Subject: LL-08-03; Lookout Large Lot (11 Lots) Frank & Judy Ragland
US 97, MP 140.76 Left; Parcel #18-17-01020-0005 (235.10 Acres)

RE: Lookout Large Lot, (LL-08-03)

TO: Trudie Pettit, Community Development Services
FROM: Randy Carbery, Planner II *rc*
DATE: May 7, 2008
SUBJECT: Lookout Large Lot Subdivision 08-03

OWN BY	DATE	JOB NO.
DP/ST/GW	03/2008	08009
CHKD BY	SCALE	SHEET
D. NELSON	1"=500'	1 OF 3

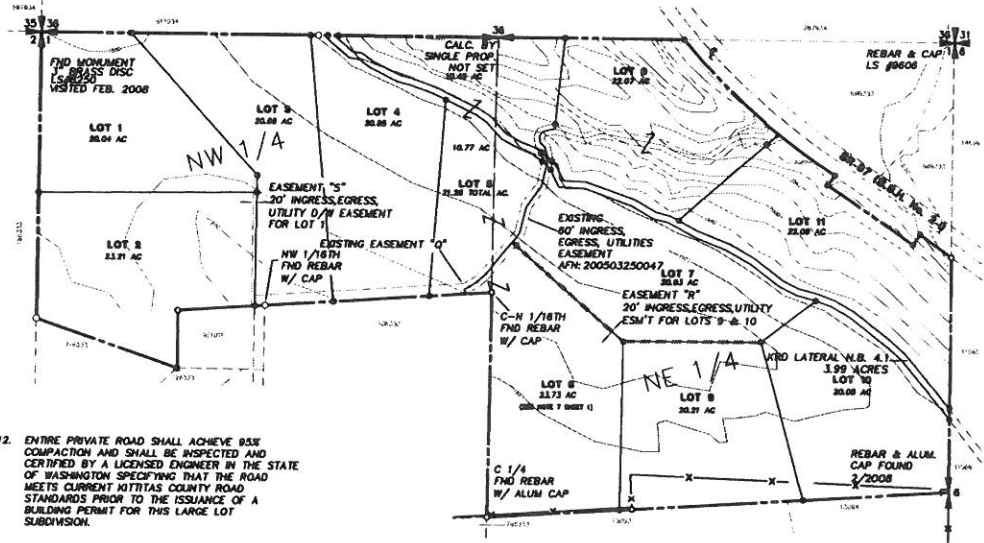
3. Contours: Sheet 1 of 3 shows contours, however, the intervals used are not easily read at the scale provided and do not provide enough detail for an effective review of the

application. The applicant shall provide updated contour information with the appropriate intervals, as required by KCC16.12.030 Existing conditions.

- A. *Contour lines at intervals of five feet for slopes less than thirty percent, and ten feet for slopes over thirty percent at preliminary review only , or the use of USGS maps to represent elevations and slopes at preliminary review may be used and where such maps are utilized at preliminary review they must be verified by Contour lines of five feet for slopes less than thirty percent and ten feet for slopes over thirty percent at final review.*

DWN BY	DATE	JOB NO.
DP/ST/GW	03/2008	08009
CHKD BY	SCALE	SHEET
D. NELSON	1"=300'	2 OF 3

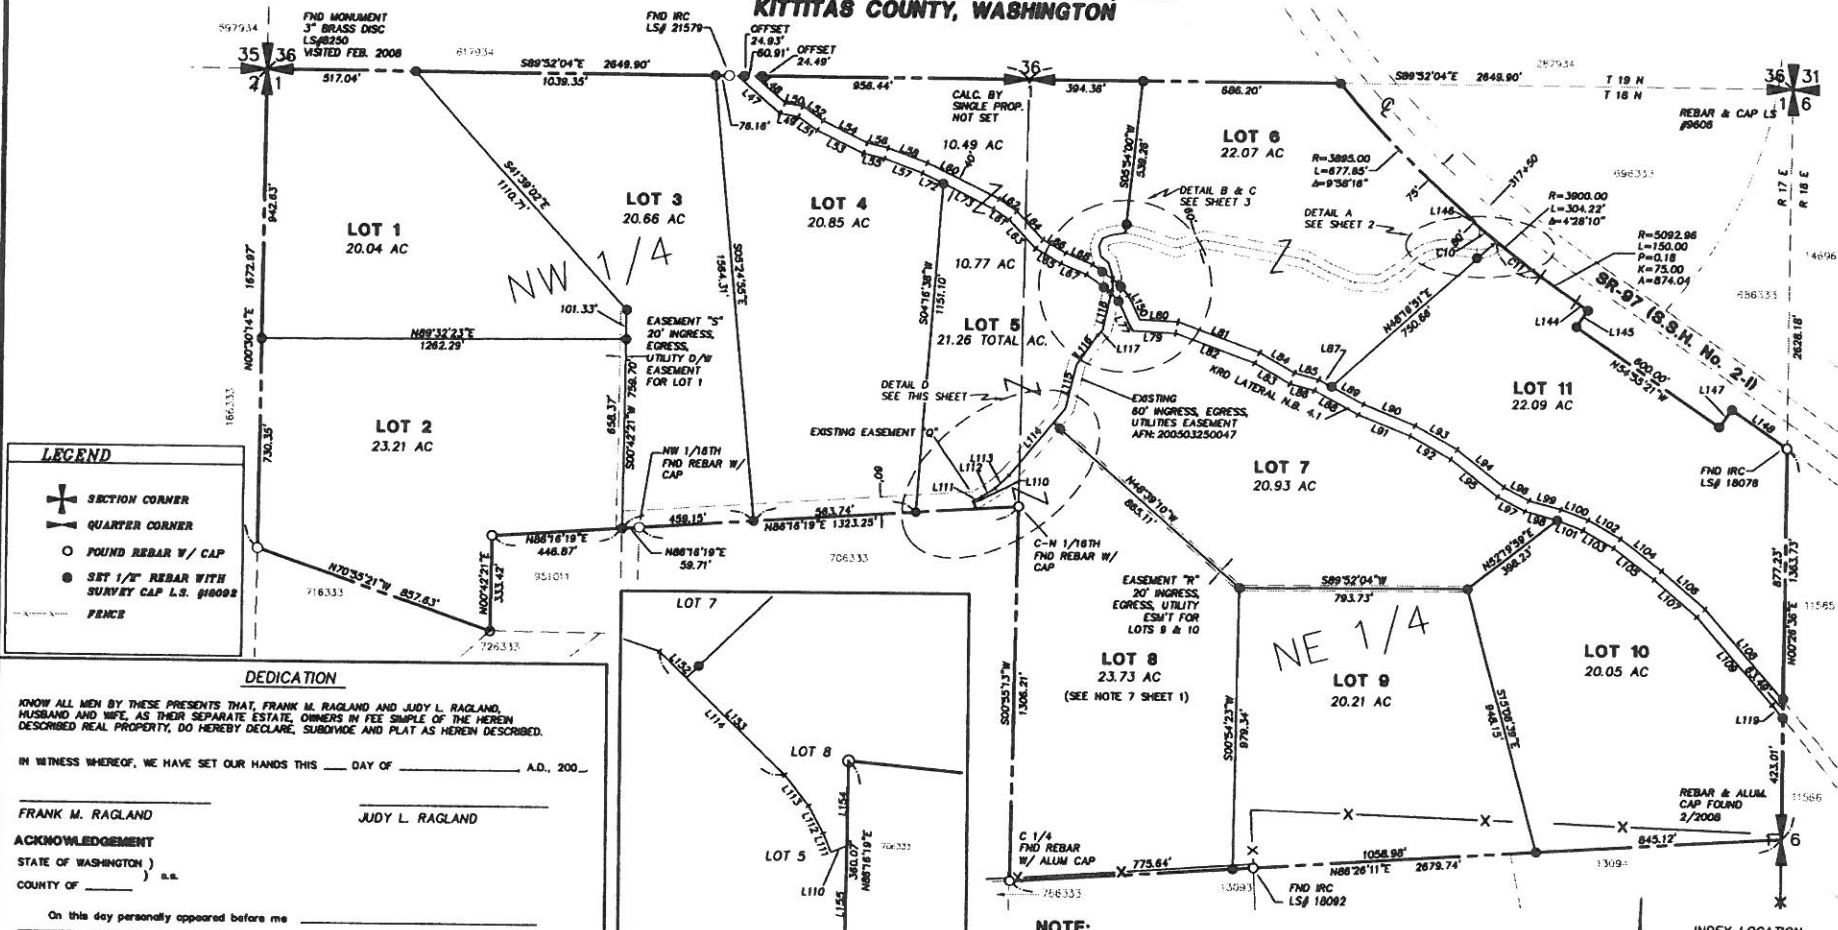
1. Access to Lot 11: It appears that access to lot 11 is proposed directly off the northwest lot corner. This may not be (functionally) a safe location for the access, given the close proximity of State Route 97 and would not meet minimum access spacing requirements:

Current Kittitas County Road Standards, Chapter 5, Page 5, Table 5-1, Access Spacing Requirements, (4): *Includes public and private roads and all other access points.*

The applicant or their appointed representative(s) shall contact our office to discuss an alternate access location for lot 11. An approved access location for lot 11 shall be identified prior to final approval of the Large Lot Subdivision

2. Cul-de-Sac: The applicant has indicated that the location of the cul-de-sac or turn around area is further south of this proposed subdivision. However, no cul-de-sac or turn around area is identified on the Large Lot Subdivision application.

The location of the cul-de-sac or turn around area shall be depicted on the face of the Large Lot Subdivision application, prior to final approval of the Large Lot Subdivision., regardless of its location.

5. Private Road Improvements: Access to lots 2, 3, 4, 5, 6, 7 & 8 shall be via Easement "R" as depicted on the face of the plat. Access shall be a joint-use access and Access shall be constructed as a Low-Density Private Road. See Kittitas County Road Standards, 9/6/05 edition.

7. Joint-Use Driveway: Access to lots 9 & 10 shall be via Easement "R" as depicted on the face of the plat. Access shall be a joint-use access and shall serve no more than two tax parcels. Per Kittitas County Road Standards, 9/6/05 edition.
- a. Access easements shall be a minimum of 20' wide. The roadway width shall have a minimum width of 12'.
 - b. The surface requirement is for a minimum gravel surface depth of 6".
 - c. Maintenance of driveway approaches shall be the responsibility of the owner whose property they serve. The County will not maintain accesses.
 - d. Any further subdivision or lots to be served by proposed access may result in further access requirements.

Single-Use Driveway: Access to lot 1 shall be via Easement "S" as depicted on the face of the plat. Access shall be a single-use access shall serve no more than one lot. Per Kittitas County Road Standards, 9/6/05 edition.
